**HIGHWAY REPORT ON PROPOSALS FOR DEVELOPMENT**

<b>DISTRICT:</b>	Bassetlaw	Date received	16/01/2023
<b>OFFICER:</b>	David Askwith		
<b>PROPOSAL:</b>	Proposed Two Bedroom Detached Dwelling	D.C. No.	B/23/00012/FUL
<b>LOCATION:</b>	45 Blyth Road Oldcotes Worksop Nottinghamshire S81 8JA		
<b>APPLICANT:</b>	Mrs Debra Proctor

This application seeks permission for a dwelling in the rear garden of an existing residential property.

| content: Proposed Site & Location Plan | |

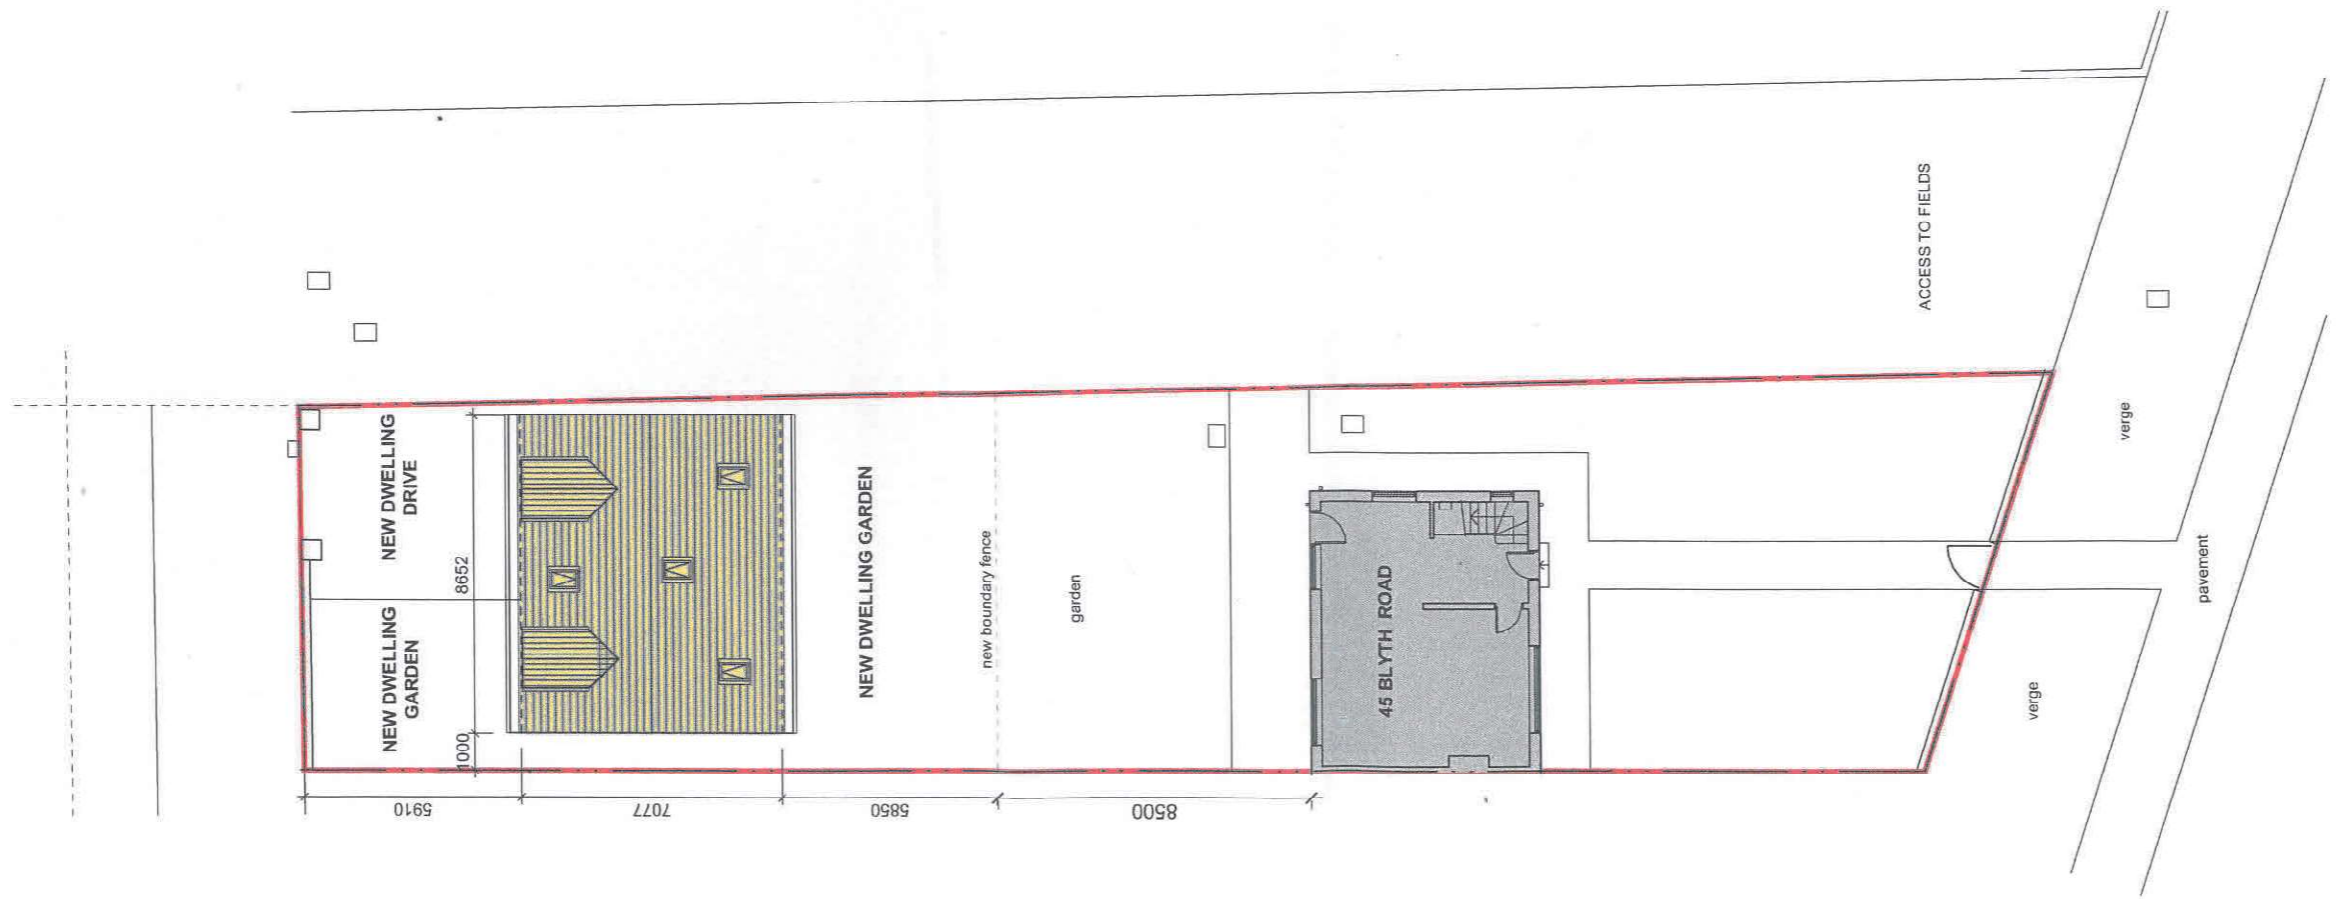
- The application site does not connect to the all-purpose public highway and no right of access to the site is shown. The all-purpose public highway finishes in the vicinity of the end of the existing footway at the rear of No. 41.

- The proposed block plan should include details of alternative off-street car parking provision to be used in association with the existing residential property.

- Adequate off-street car parking should be provided for use in association with the proposed dwelling, in accordance with the District Council's Supplementary Planning Document 'Residential Parking Standards'. The Highway Authority advises that a garage should only be counted as a parking space where it has minimum internal dimensions of 3m x 6m. Parking spaces should each be a minimum of 3m in width (3.3m where abutted by a wall, fence etc. on one side) and 6.1m in length when located in front of an 'up and over' style garage door. Generally, 6m of manoeuvring space is required behind a parking space.

At this time, the Highway Authority OBJECTS to the proposal as the application site does not connect to the all-purpose highway network, the proposal has inadequate off-street parking provision and the development would currently result in the loss of off-street car parking associated with the existing residential property.
